<b>Client</b>	Hawthorn
<b>Project</b>	Portland, ME
<b>Lead Designer</b>	
<b>Production Manager</b>	Jason DiOrazio
<b>Production Staff</b>

SHEET
E3.6

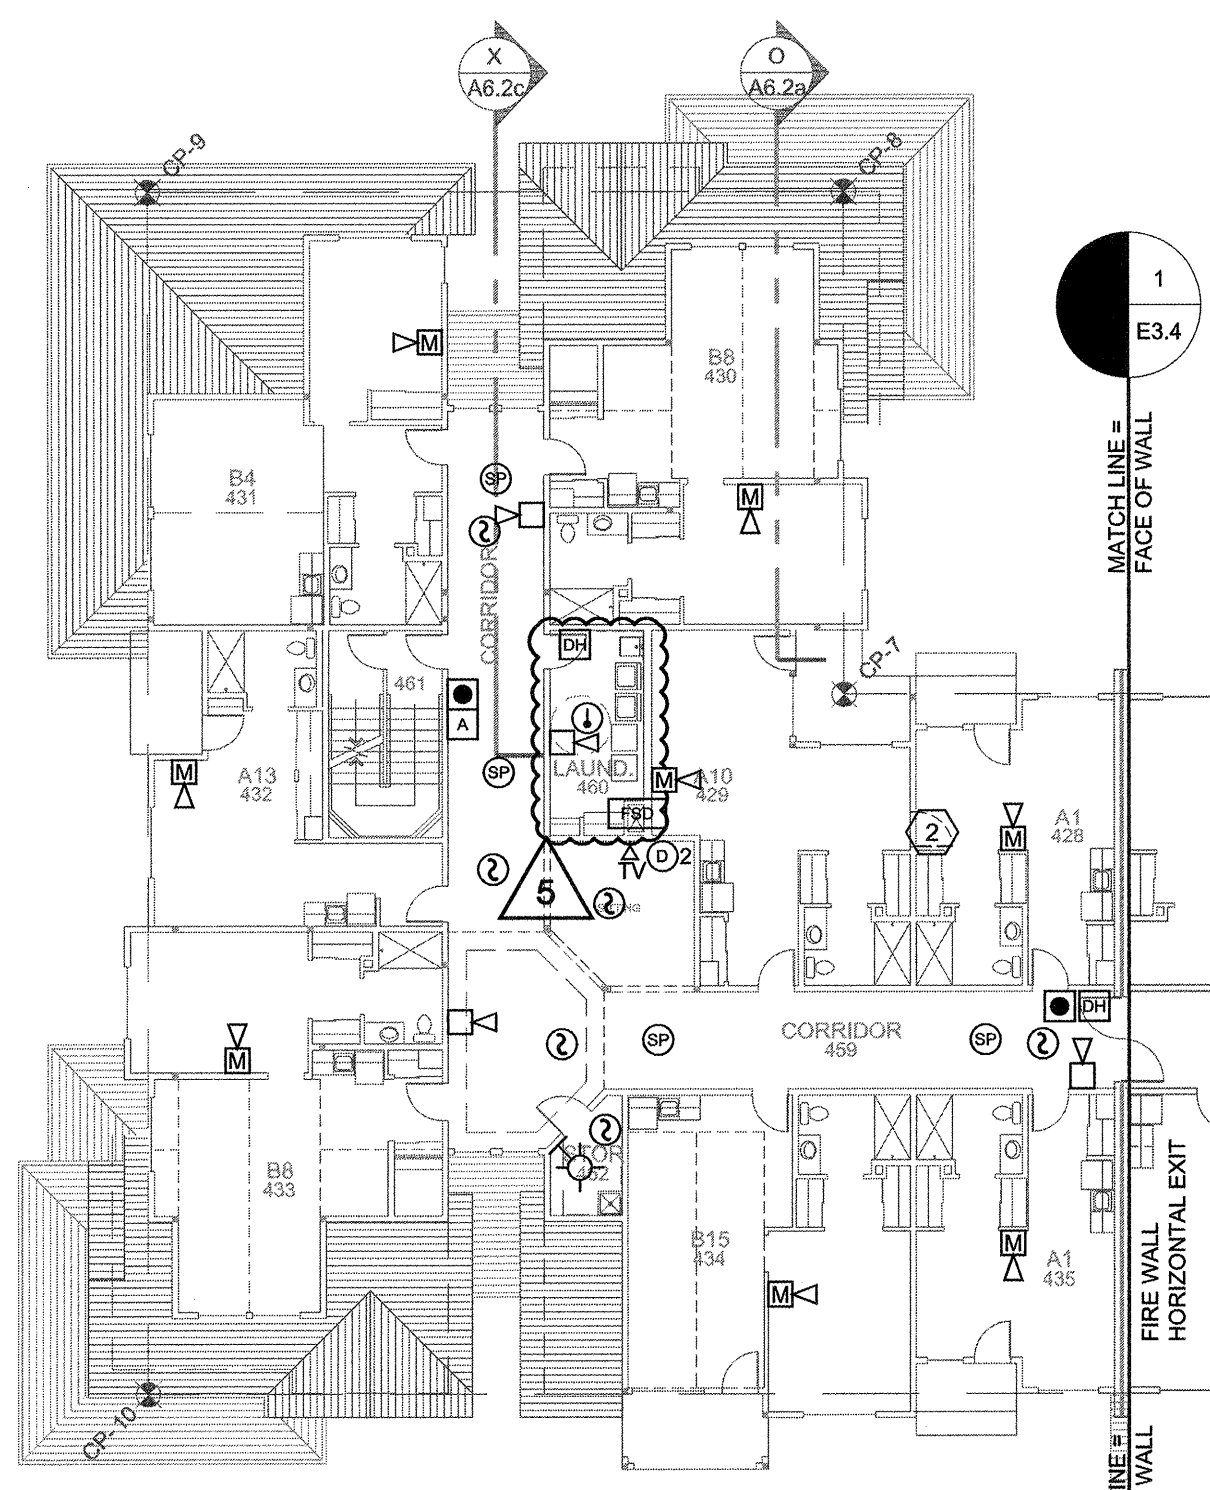
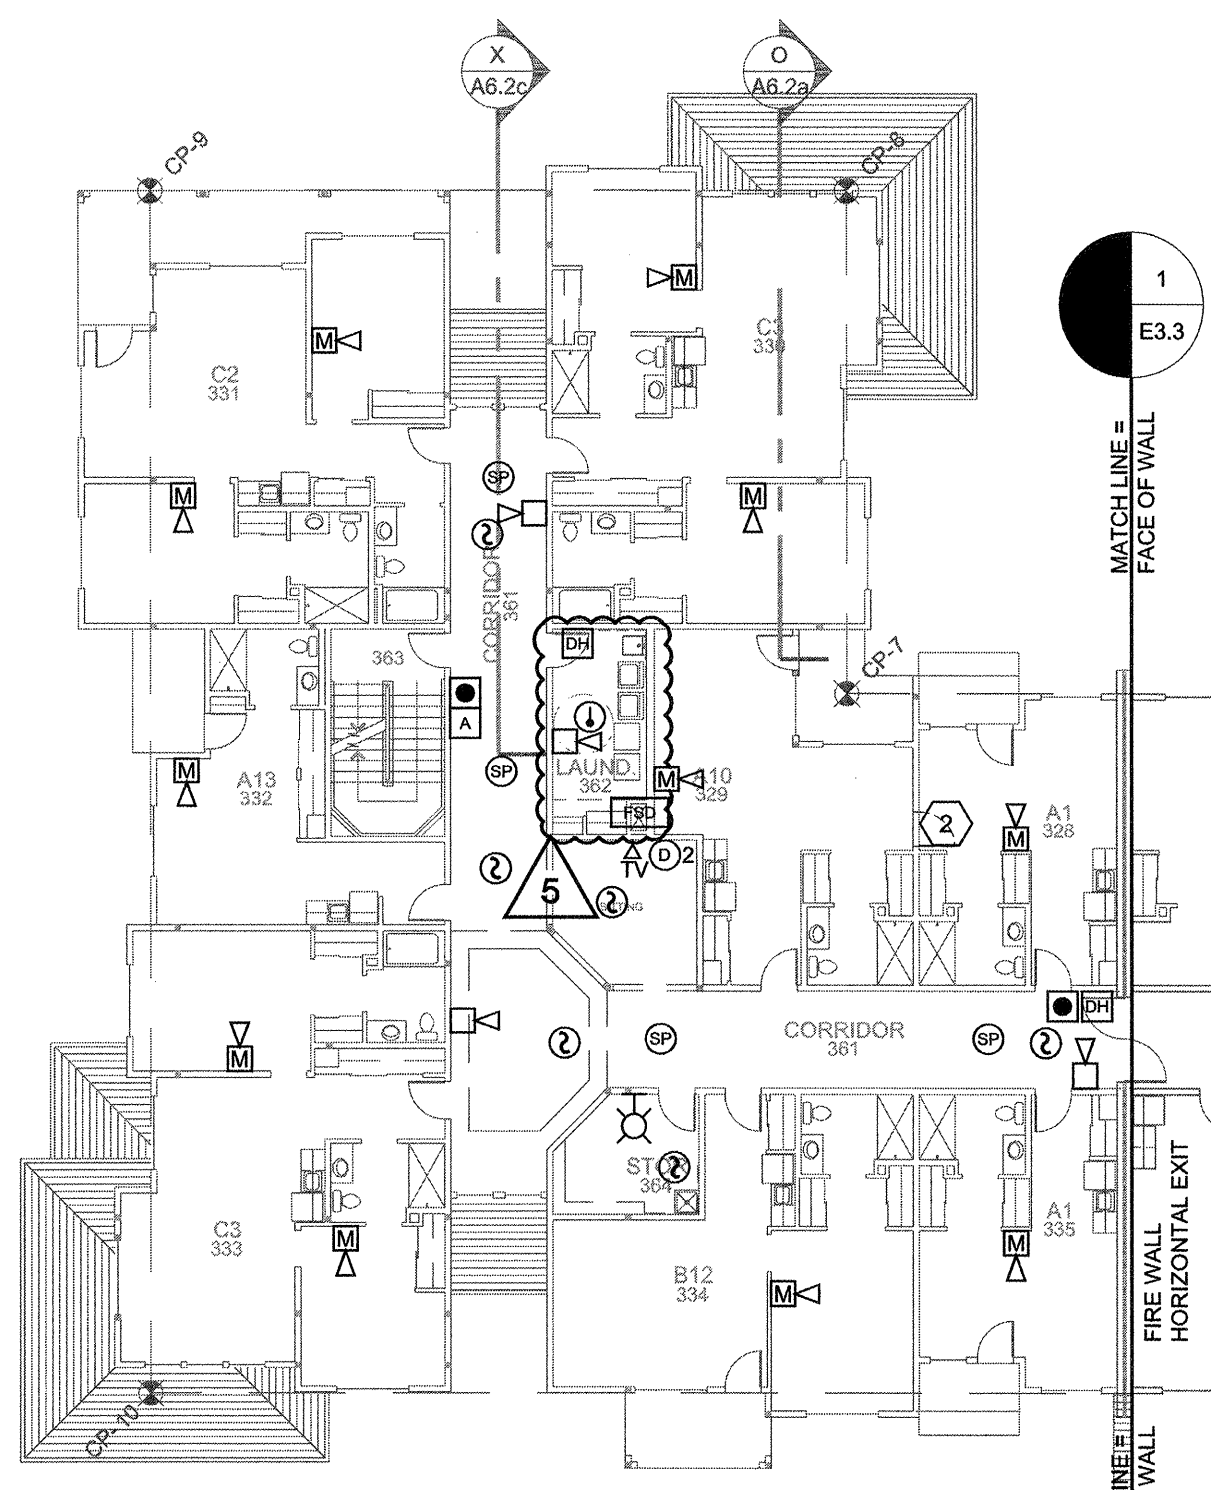
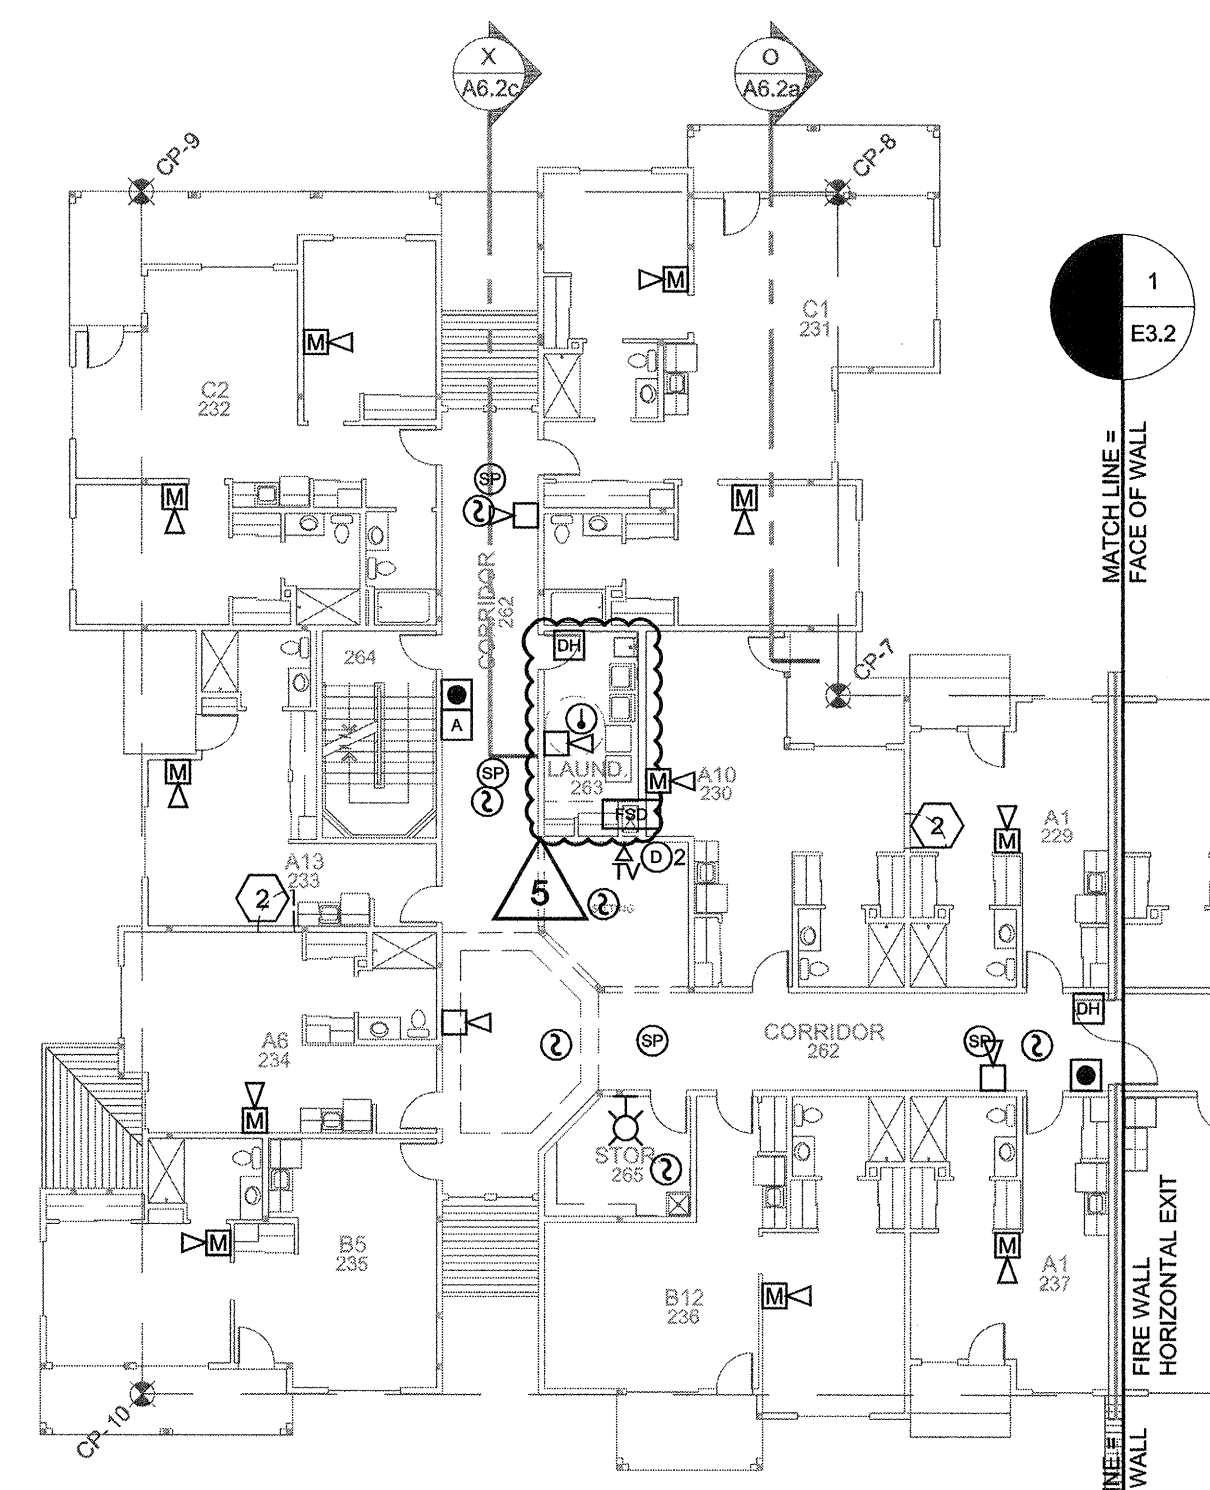
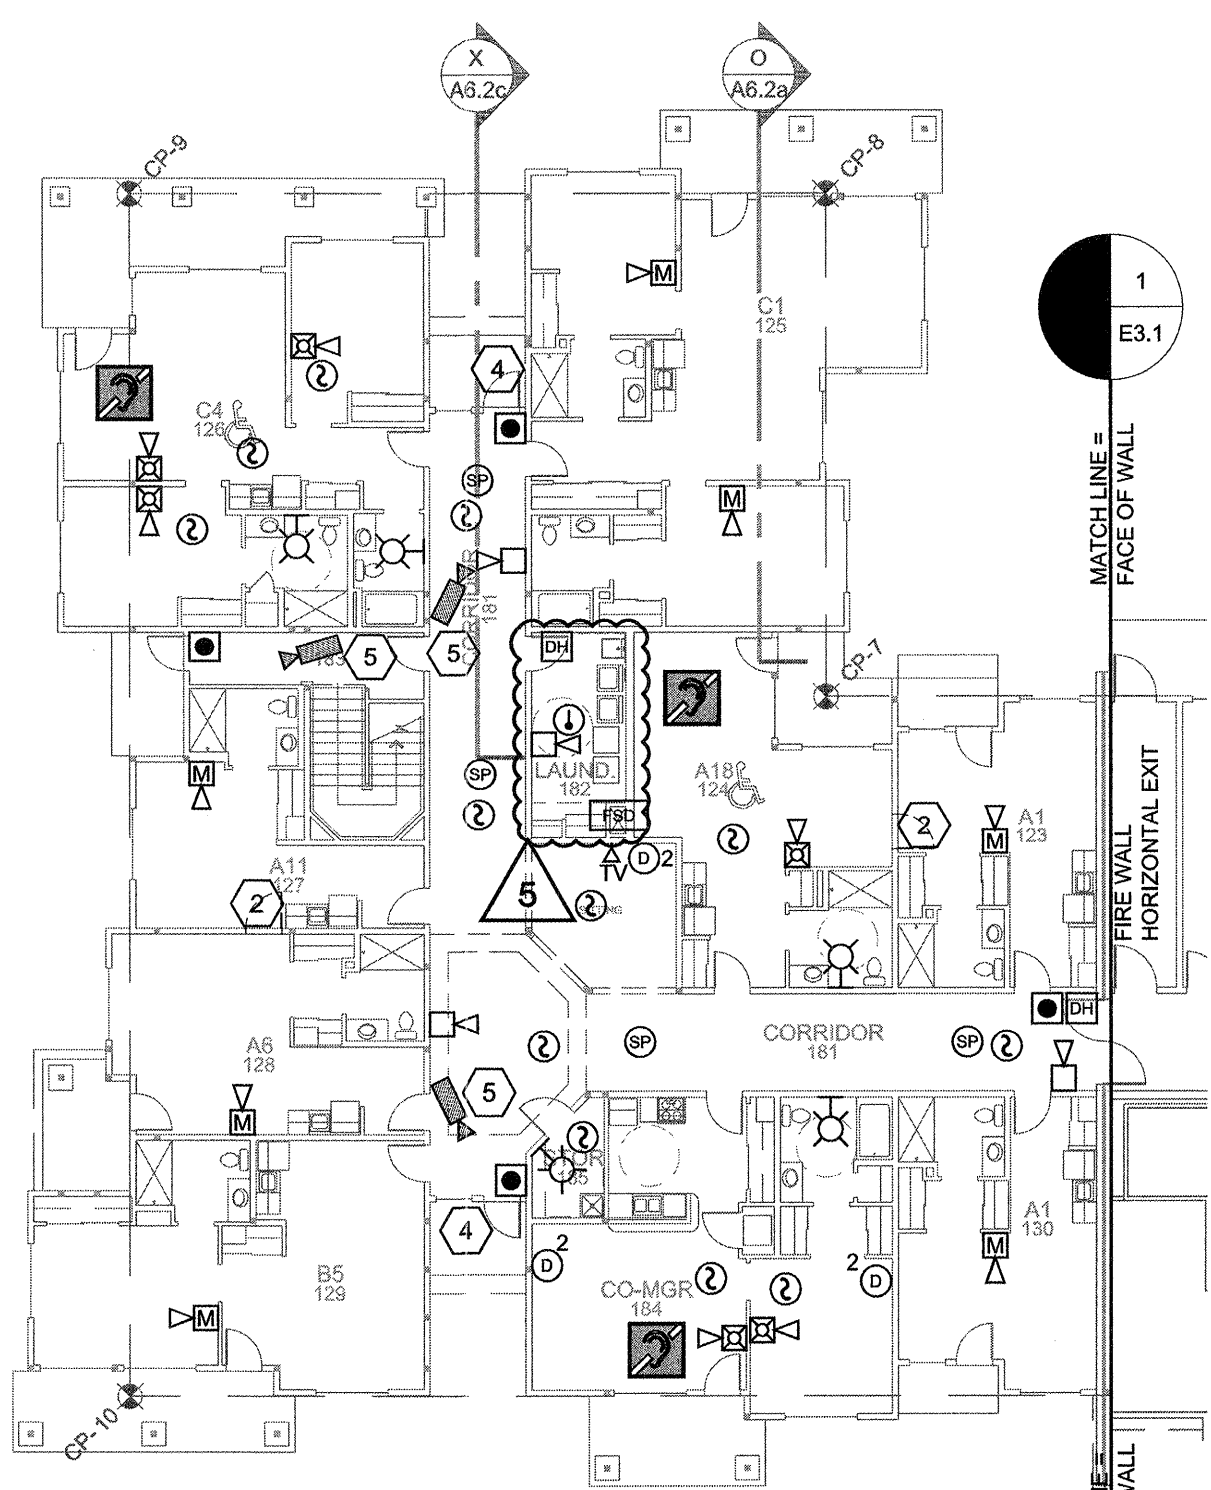
5	E2.2b	Detail 11 revised	Y		8/26/2016
5	E3.1	Rear foyer area revised, Office/Marketing area modified with low voltage equipment	Y		8/26/2016
5	E3.5	Laundry room updated	Y		8/26/2016
5	E3.6	Laundry room updated	Y		8/26/2016
5	E4.2	Detail 12 added to sheet	Y		8/26/2016
5	E5.0	Office/Can Wash area updated. Kitchen equipment at patio between Staff and Private Dining updated	Y		8/26/2016
5	E5.1	Low voltage information added to Office/Marketing detail. Switches moved out of pantry area in Manager and Co-Manager units. HDMI connection called out in Media Room	Y		8/26/2016
5	E5.5	Transfer fan in B2 unit relocated	Y		8/26/2016
5	E5.9	Lights added at B28 unit, transfer fan in BD1 unit relocated	Y		8/26/2016
5	SC1.1	Rear foyer increased in size	Y		8/26/2016
5	SC2.1	Specifications for SEF-1 updated	Y		8/26/2016
